Appeal Decision

Appeal Ref: APP/R4408/D/25/3359585

51A Huddersfield Road, Barnsley S75 1DR

- The appeal is made under section 78 of the Town and Country Planning Act 1990 (as amended) against a refusal to grant planning permission.
 - The appeal is made by Mr Dominic Bottomley against the decision of Barnsley Metropolitan Borough Council.
 - The application Ref is 2024/0949.
 - The development proposed is Alterations to roof and conversion of loft into habitable space and erection of front porch.
-

PROPOSED FRONT ELEVATION SCALE 1:100

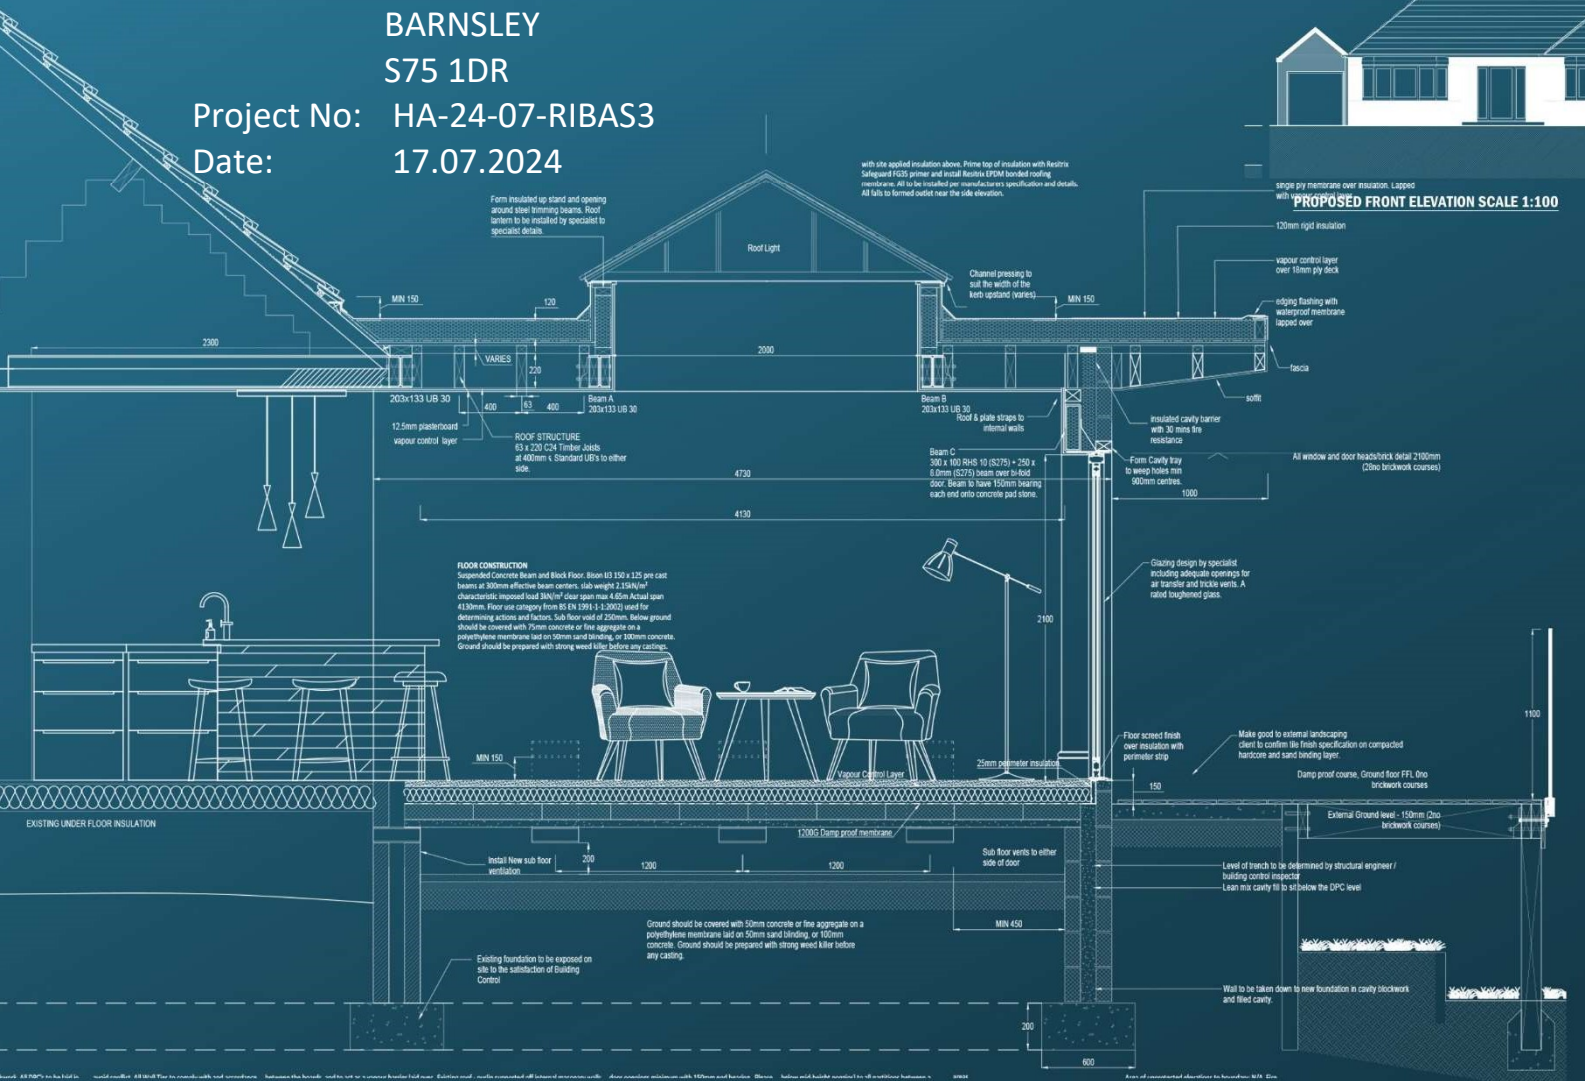
7. The proposed loft conversion would lead to the formation of a gable in place of the existing hipped roof and a large dormer window to the rear elevation. The resulting gable would be a highly visible alteration to the front elevation that would unbalance the careful composition of the pair of semi-detached dwellings, eroding their shared symmetry. As such, seen alongside the existing adjoining dwelling, this proposal would represent an incongruous addition at odds with the character and appearance of No 51A and No 51B.
